**Consultation Response from KC,
Lead Local Flood Authority**

2023/93464 Land at, Lingards Road, Slaithwaite, Huddersfield, HD7 5HY

Date Responded: 24th July 2024

Condition 17 – Drainage Details and Post completion maintenance plan

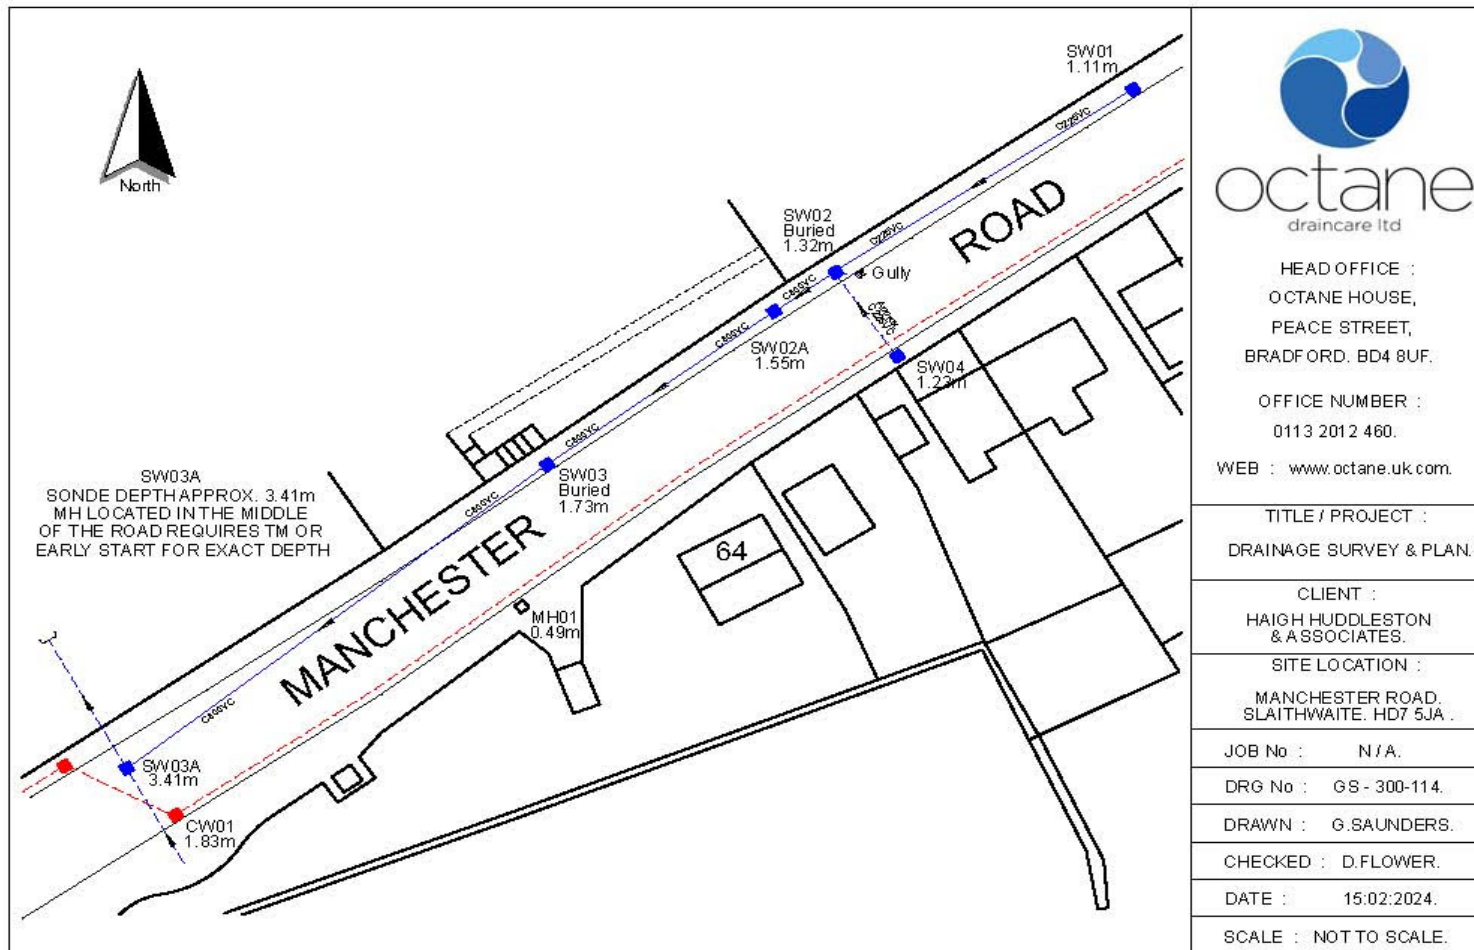
No calculations are provided for the storage of the separate attenuation system for the eastern part of the site. **Calculations have been provided but show a flow control device of 74mm. This is below the minimum requirement of 75mm with a preference for 100mm.**
